PORTLAND MAINE

RE: Review Comments for 50 Ball Park Drive - Single Family Site Plan

Project Name: Single Family Home
Project ID: 2013-01925
Project Address: 50 Ballpark Drive **CBL:** 371 - A - 035-001
Planner: Jean Fraser

**SITE PLAN**

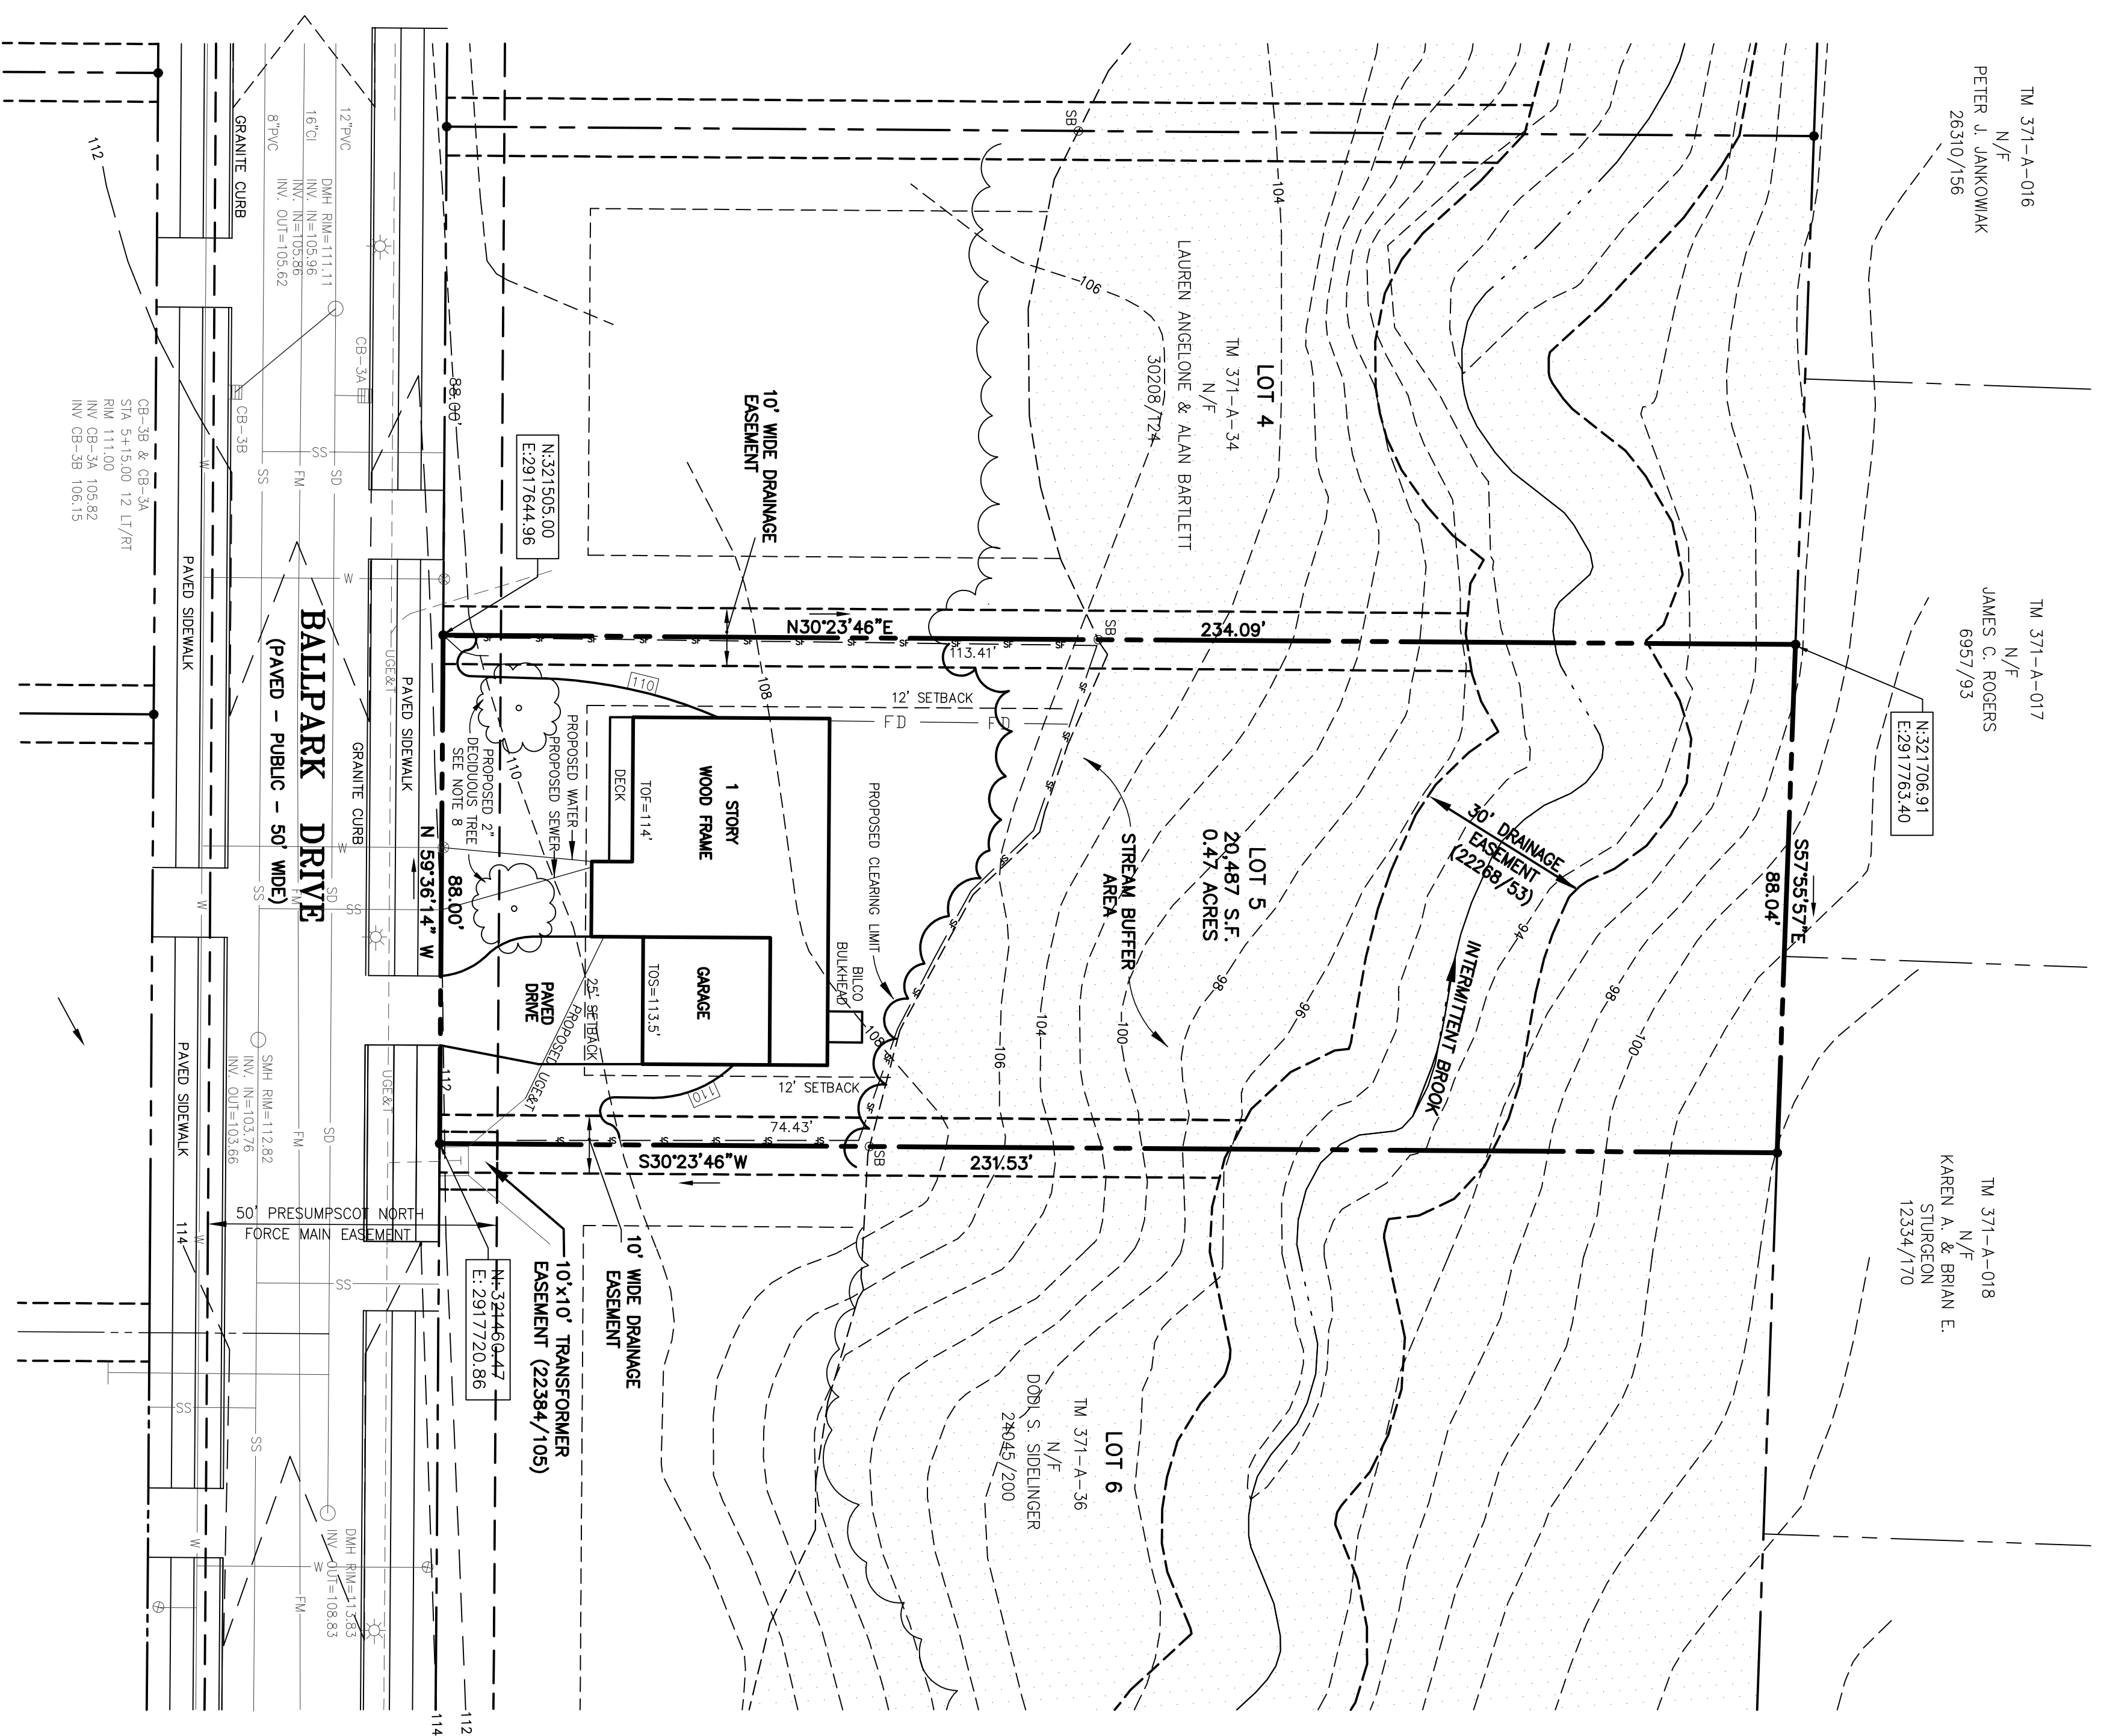
1. Please submit a revised survey/site plan that includes the following information:
 - Stamped by a Professional Surveyor (re survey information);
 - Shows the location of installed stream buffer pins. The edge of the area of stream buffer non-disturbance shall be flagged on site prior to any site work.

1. Please submit a revised site plan that includes the following information:
 - Please add the soil type to the site plan;
 - Please show the proposed contours around the house (including to allow the daylighted basement window) and add proposed grading contours to clarify the swales on each side of the house so that it is clear that neighboring properties are not negatively impacted by stormwater surface drainage.

1. Please submit a revised site plan that includes the 10' x 12' deck and stairs as shown on the building plans (it is not shown on the site plan);
2. Deed description of just lot 5 including any existing proposed easements and all restrictions related to the 75 foot undisturbed stream buffer. This deed will have to be recorded in the registry of deeds before the certificate of occupancy is issued.
